Project Title: Blvd 2500 **Building Permit #** _____ **Hydrology File #** _____
DRB# PR-2018-00158 **EPC#** _____
Legal Description: TRS 1 2 & 3 Unit 1 Together w/TRS 4 5 & 6A Unit 2 Dale J Bellamahs Carlisle Replat & Lot 22A Plat of Lt 22A City Address OR Parcel 2500 & 2412 Carlisle Blvd NE
Blk 22 Timoteo Chavez Addition & Port of BLKS N & O Timoteo Chavez Addition

DATE SUBMITTED: 03.21.2023

**RE: RESPONSE TO CONCEPTUAL TRAFFIC CIRCULATION LAYOUT COMMENTS
BLVD 2500
NE CORNER OF CARLISLE BLVD & CUTLER AVE**

Please find the following responses addressing the review comments from correspondence dated March 17, 2023 below. These comments addressed are only the site comments provided, as we are seeking conceptual approval for preliminary/final plat submittal to the DHO. Addressal of any right-of-way comments and access easement will be addressed at a later date when seeking final approval for Building Permit submittal.

MOTORCYCLE PARKING SIGN  
NTS

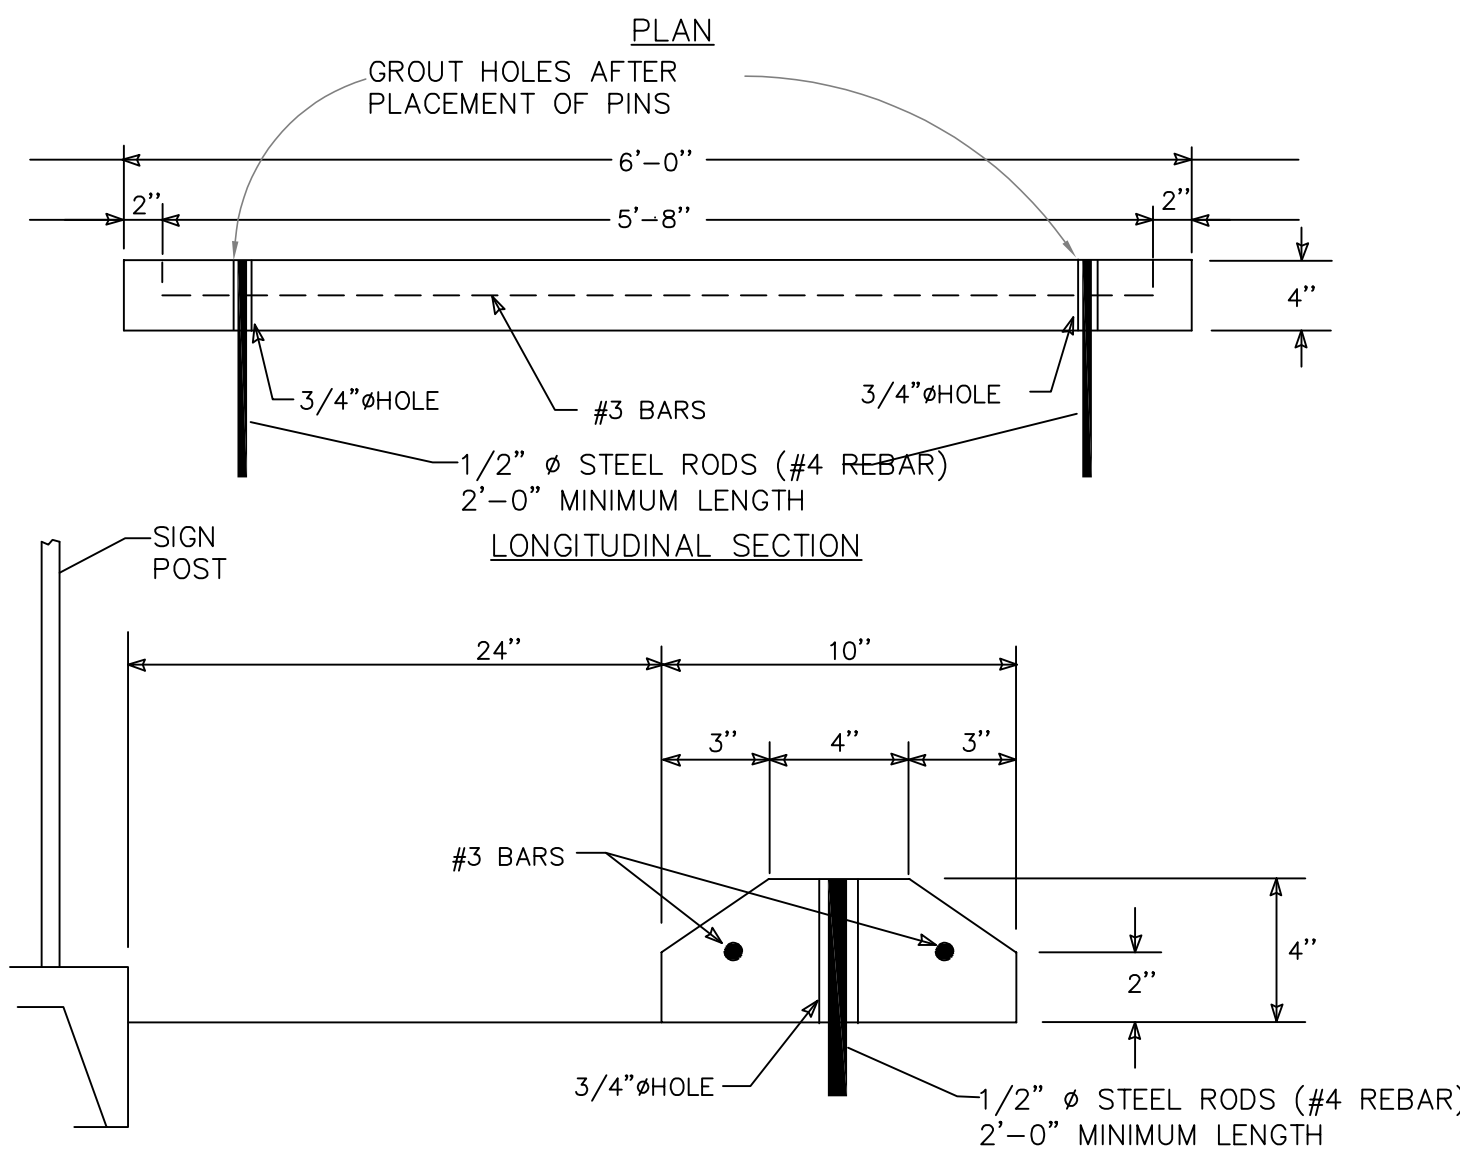
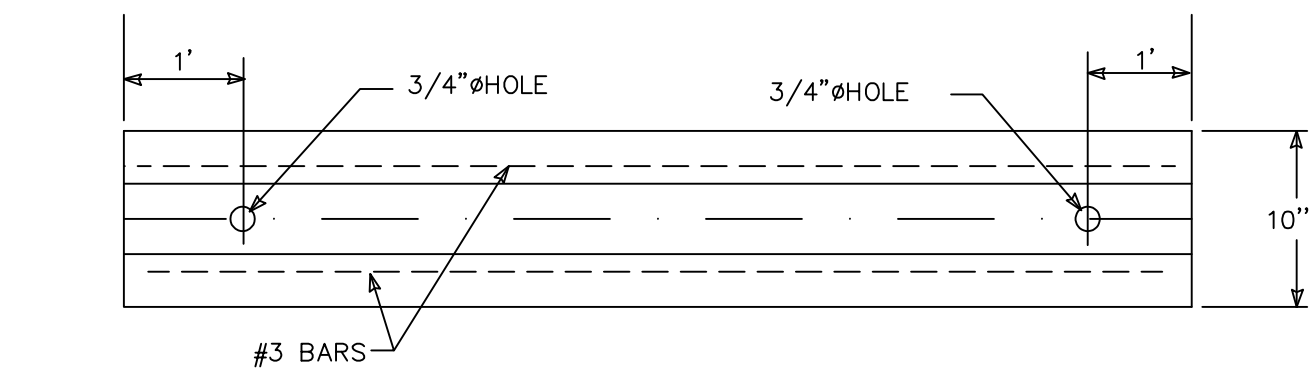
3. Provide Motorcycle parking space posted upright sign, either free standing or wall mounted per the zoning code.
RESPONSE: Keyed note 6 mentions motorcycle parking space w/ sign. A free standing sign detail can be found on Sheet C1.2.

6. Motorcycle parking spaces shall be designated by its own conspicuously posted upright sign, either free-standing or wall mounted per the zoning code.

RESPONSE: Keyed note 6 mentions motorcycle parking space w/ sign. A free standing sign detail can be found on Sheet C1.2.

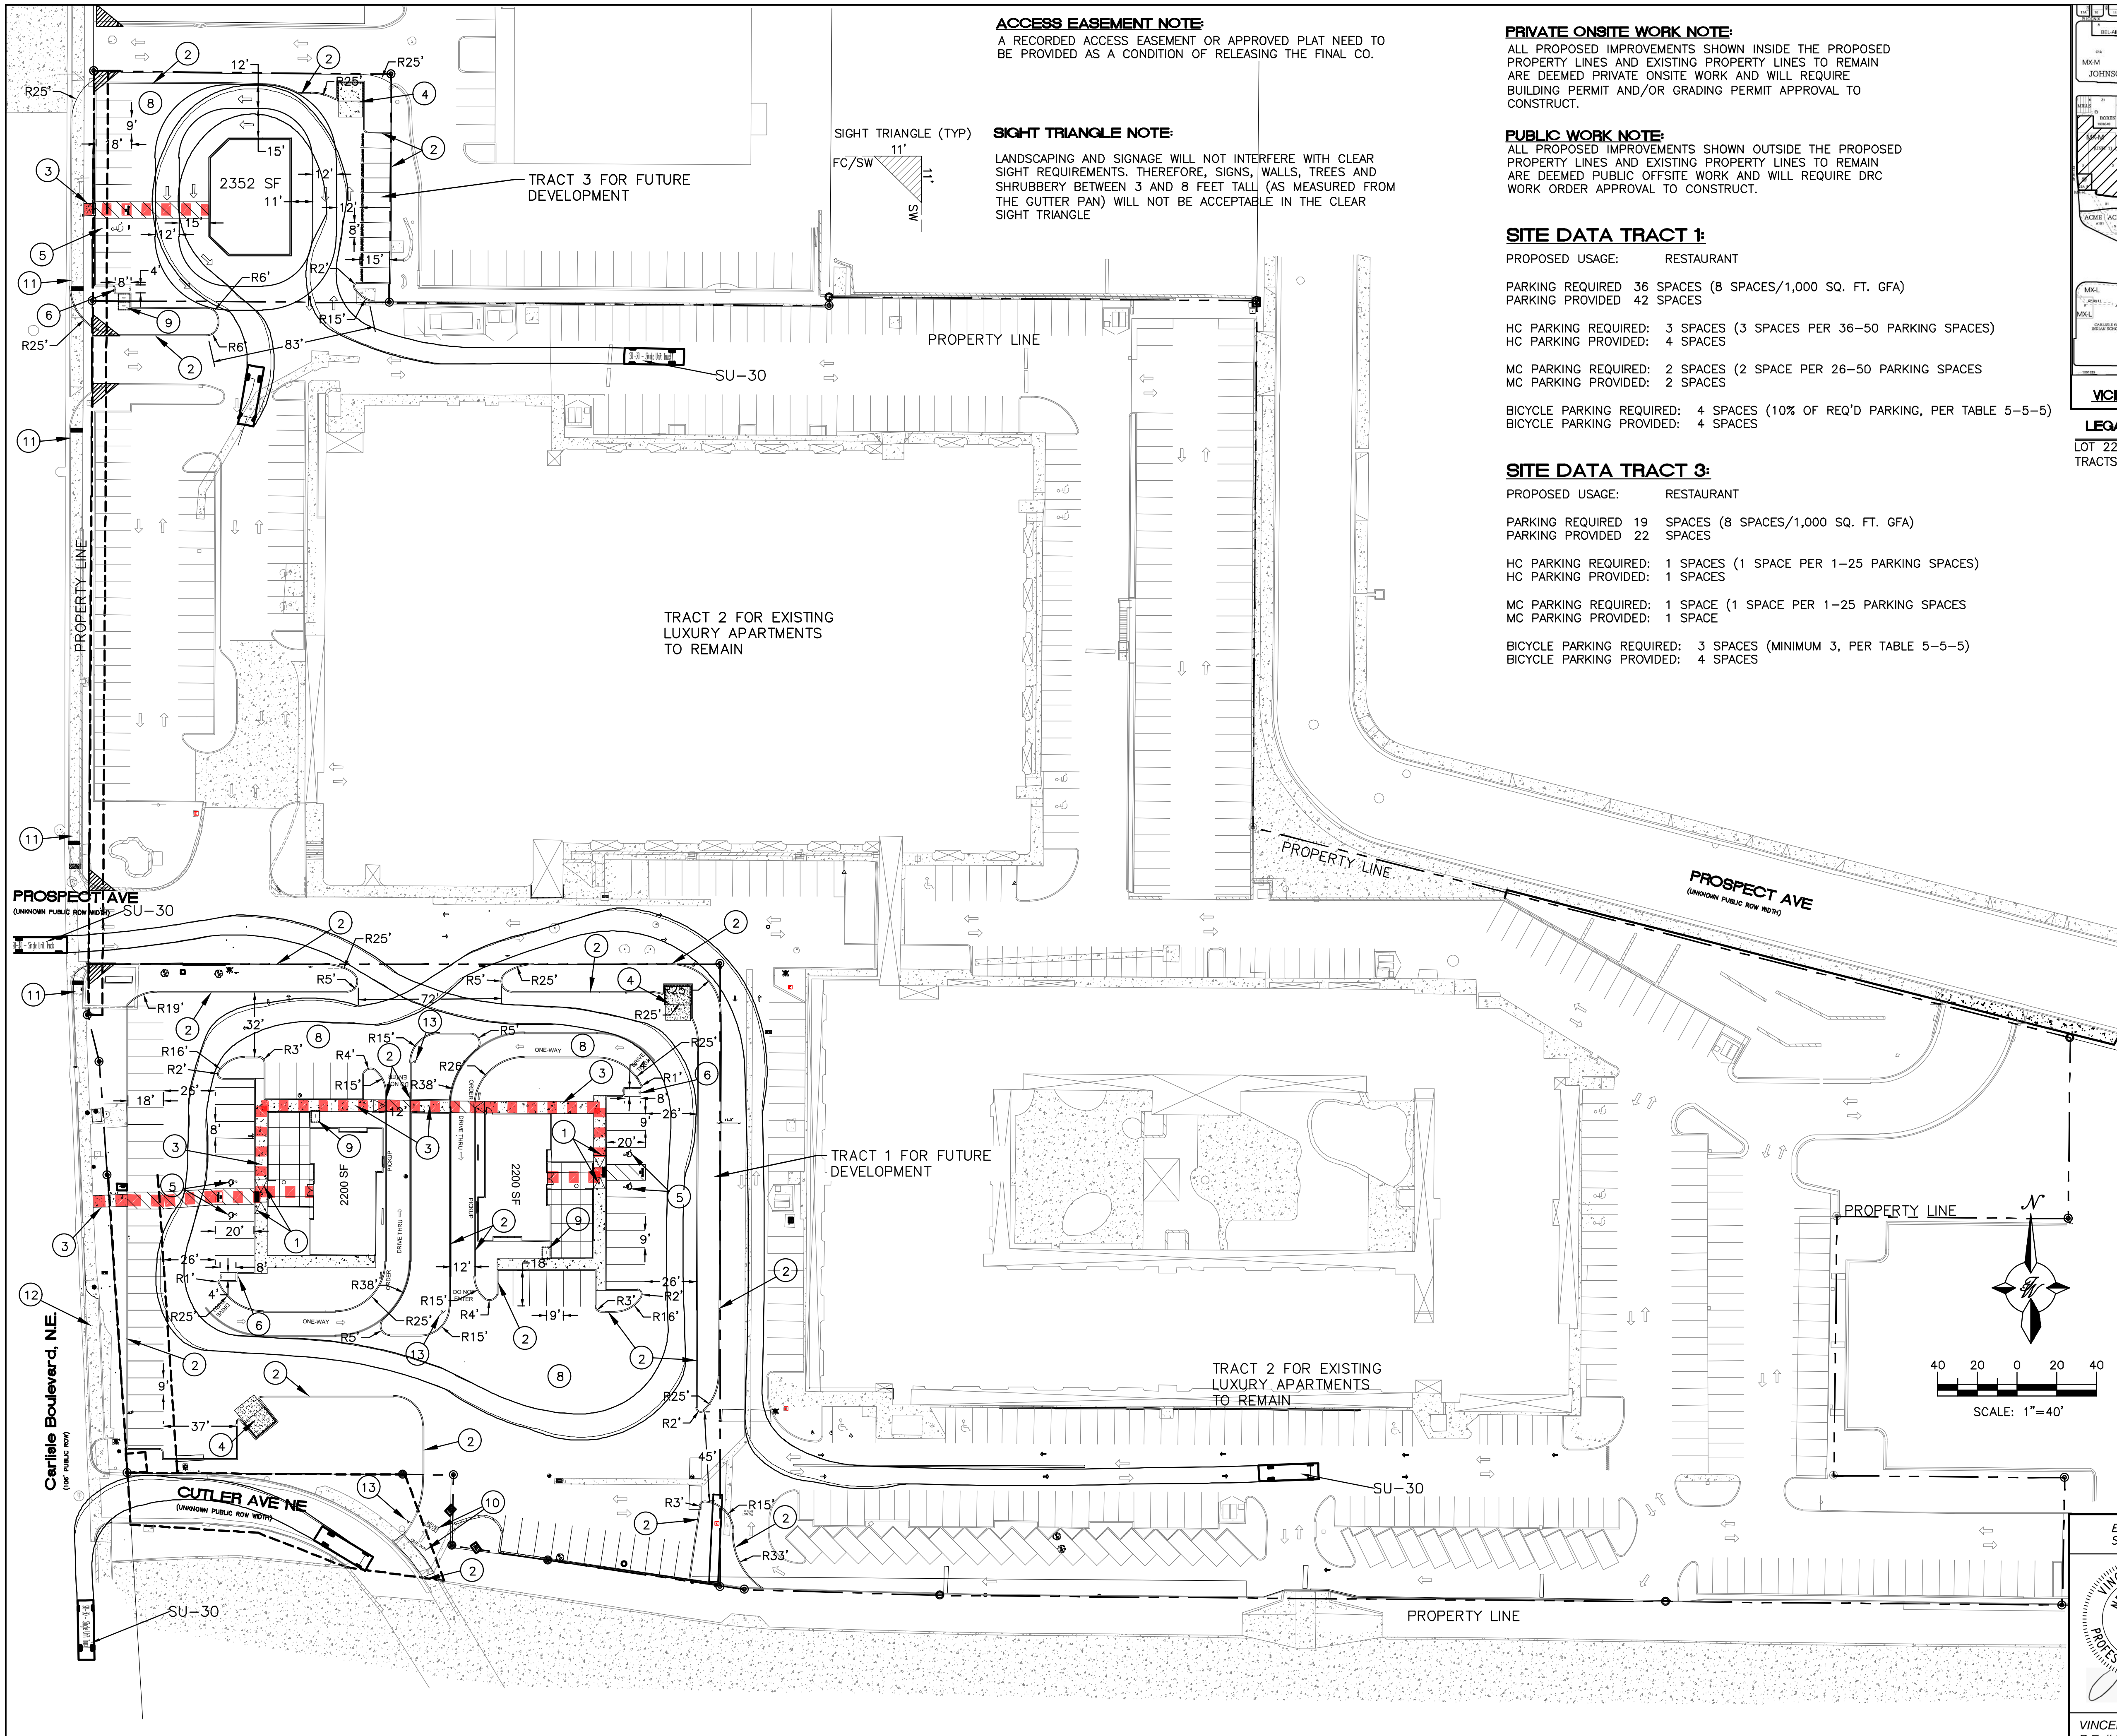
1. List the number of bicycle spaces required by the IDO.
RESPONSE: Required and provide bicycle spaces are shown under the "Site Data". Bike racks have also been added and called out with keyed note 9.

2. Grades and slopes in the parking area and/or the ADA Accessible parking areas appear to be too large. Please provide more detail.
RESPONSE: The proposed grading plan for the property was reviewed to show that all of these ADA parking areas do not exceed 2% in any direction. Keyed note 5 has been updated to stated 2% max slope in any direction.

4. Please clarify, is the site access off Cutler ONE Way? If so, please provide "ONE WAY" sign and pavement marking.
RESPONSE: The access off Cutler is one way. "ONE WAY" and "DO NO ENTER" sign and pavement markings are shown and called out as Keyed Note 10.

5. ADA Curb ramps for site accesses along Carlisle must be updated to current standard and have truncated domes installed.
RESPONSE: ADA unidirectional ramps w/ truncated domes are now shown along Carlisle to be removed and replaced and called out with Keyed Note 11.

7. Per the IDO, a 6 ft. wide ADA accessible pedestrian pathway is required from the public sidewalk to the building entrances. Please clearly show this pathway and provide details.

RESPONSE: Clear sight triangles are shown on all access points off of Carlisle Blvd.
12. Please specify the City Standard Drawing Number when applicable.

RESPONSE: A "Public Work Note" is on the plan stating that any work within public right-of-way will require DRC Work Order approval.
14. Unused curb cuts must be replaced with sidewalk and curb & gutter. A build note must be provided referring to the appropriate City Standard drawing.

RESPONSE: A 6' wide pathway is highlighted in red to show ADA access from the public sidewalk to each building.
8. Per the IDO, a 6 ft. wide ADA accessible pedestrian pathway is required from the ADA parking stall access aisles to the building entrances. Please clearly show this pathway and provide details.

RESPONSE: "One Way" and "Do Not Enter" signage and pavement markings are shown on the plan for the drive-thru lanes.
11. Show the intersection clear sight triangle at the north side site access off Carlisle Blvd.

RESPONSE: Keyed Note 12 calls for replacing existing driveway with curb, gutter, and sidewalk per COA Std Dwgs 2415A and 2430.
15. Add a note stating "All broken or cracked sidewalk must be replaced with sidewalk and curb & gutter." A build note must be provided referring to the appropriate City Standard drawing.
